Our Ref: A/213/17/T

Fell 3No. Sycamore trees & surgery to various trees.

Land at West Drive Angmering West Sussex

Thank you for your internet representation made on 31st January 2018 which has been recorded as '**an objection**' with the comments as follows:

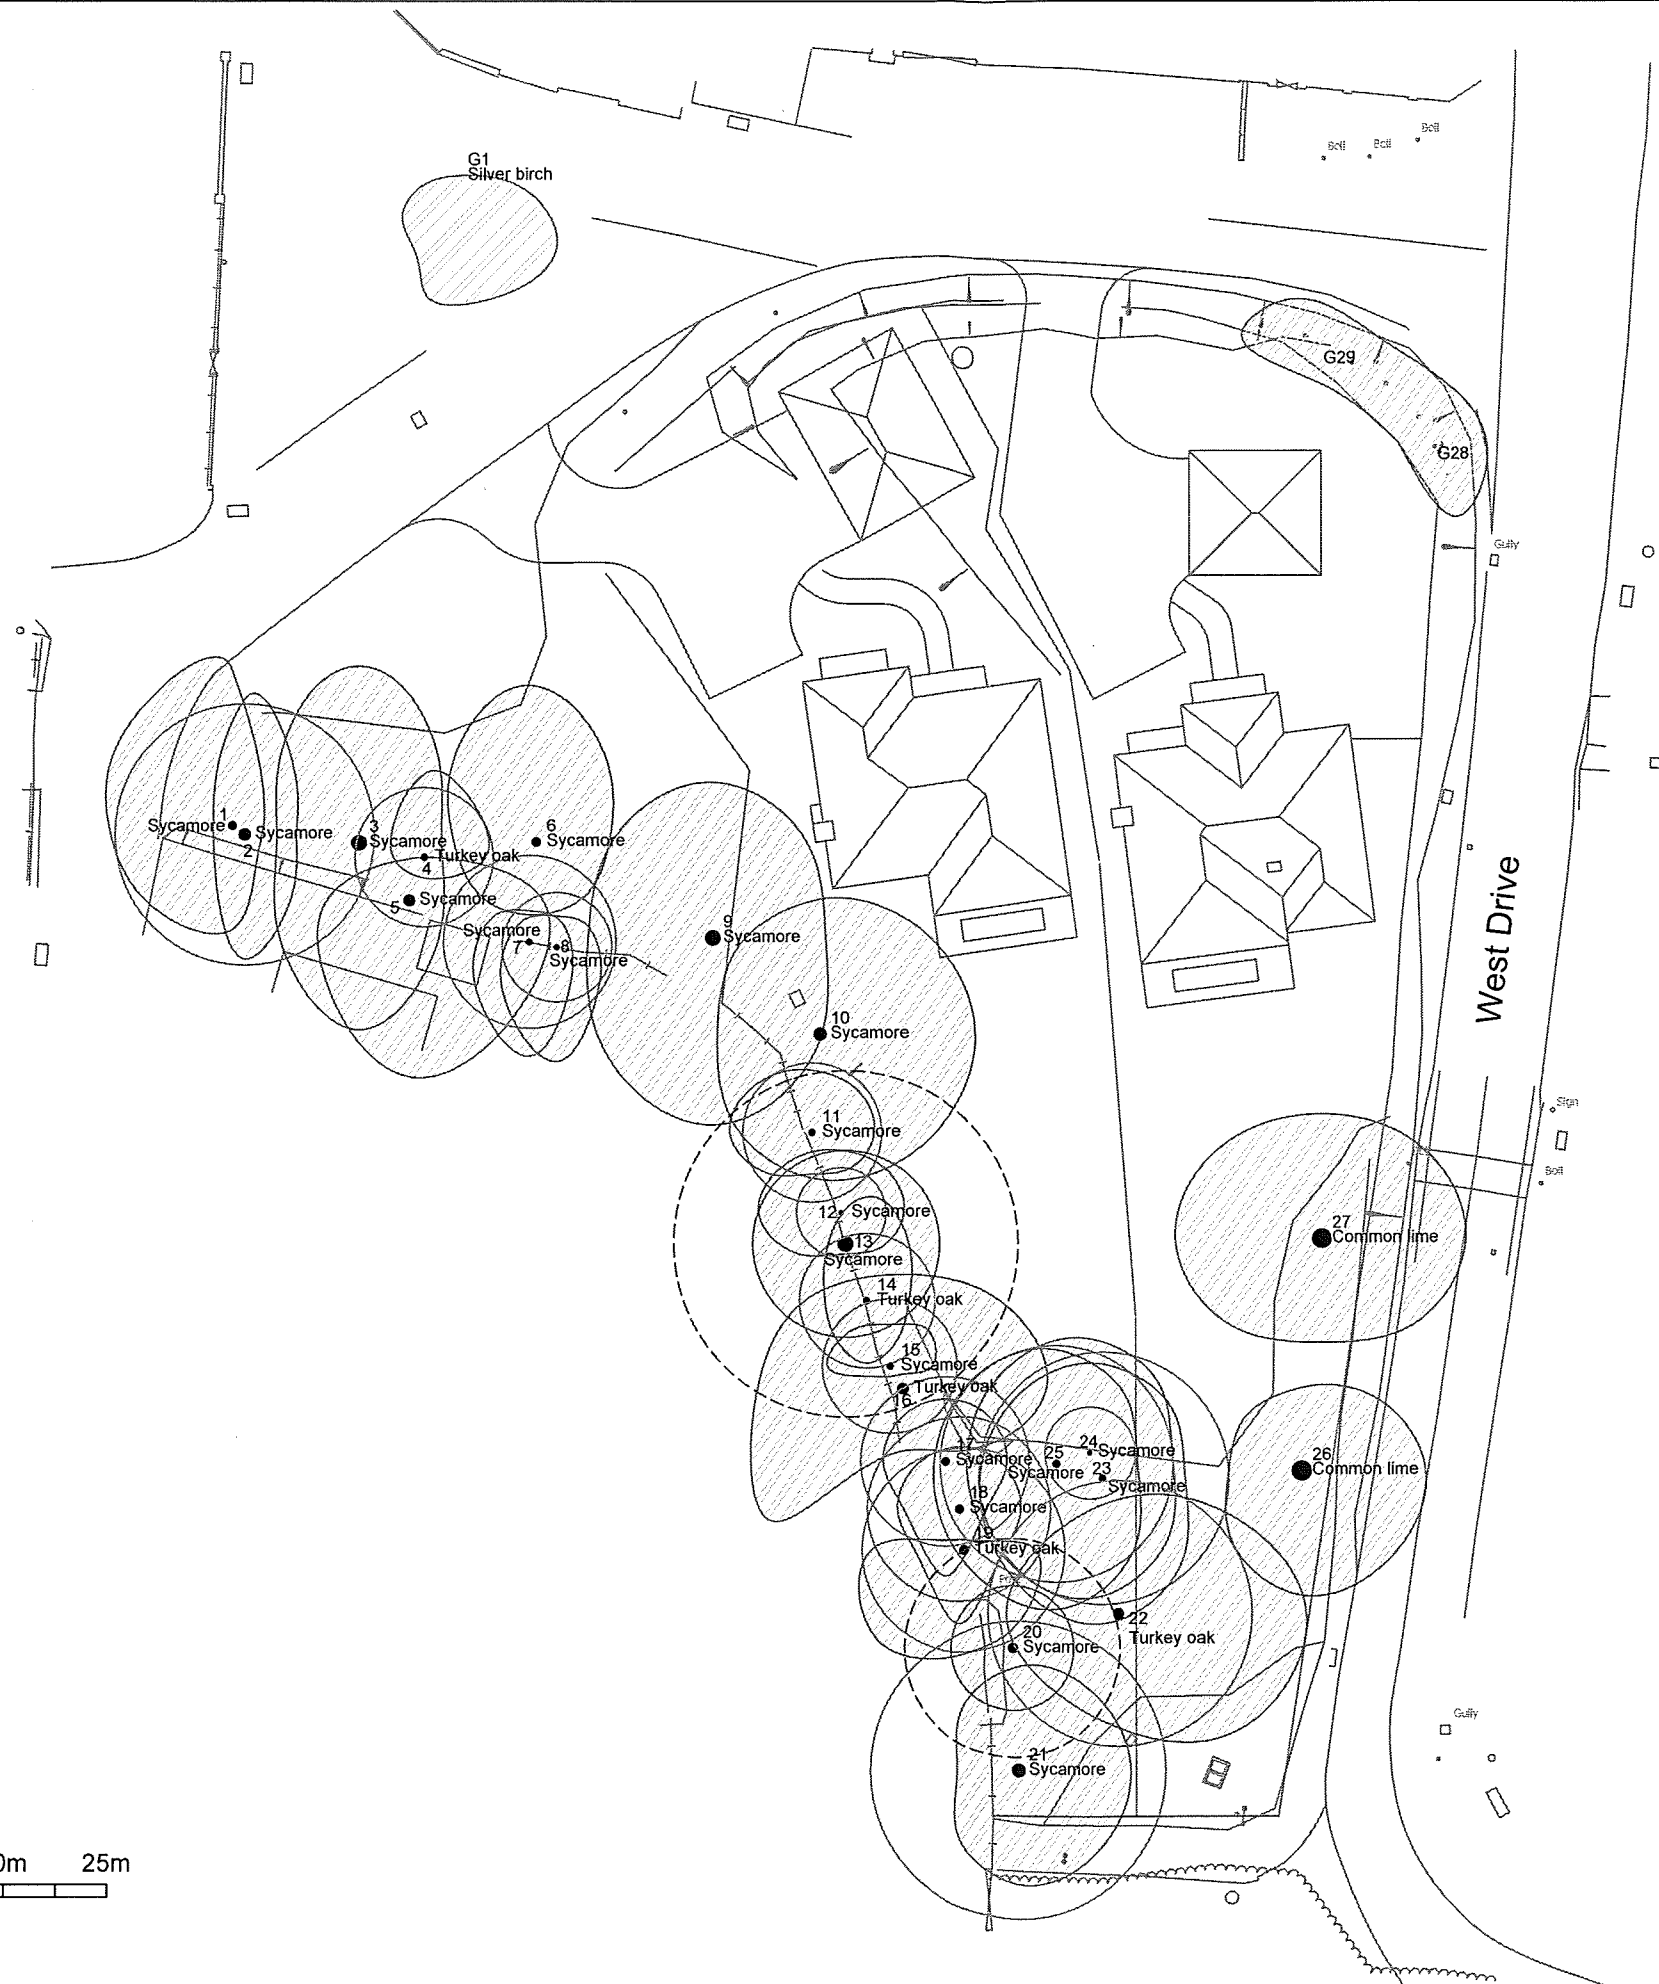
The application dated 17/01/2018 bears a hand written notation 'Fell 3 Nos sycamore trees and surgery to various trees', however there is some variation with both the Notes for the Tree Schedule and the Tree- Works Specification. Additionally, the Tree location plan includes reference GI Silver birch, which are a feature of New Road lying outside the developer's land, and should not be felled. The Tree - Works Specification refers to Group 1- Self Set Elms, which does not appear on the location plan.

Tree Works Specification reference T9 suggests reduction in crown by 1.5 - 2 metres over proposed southern elevation of new build. The officer's report for the related application A/182/16/PL recommended the repositioning of one of the planned properties, to reduce pressure to prune the tree(s) and any related negative impact.

The Tree Location plan does not appear to show all seven trees planted as a requirement under appeal APP/TPO/C3810/1710.
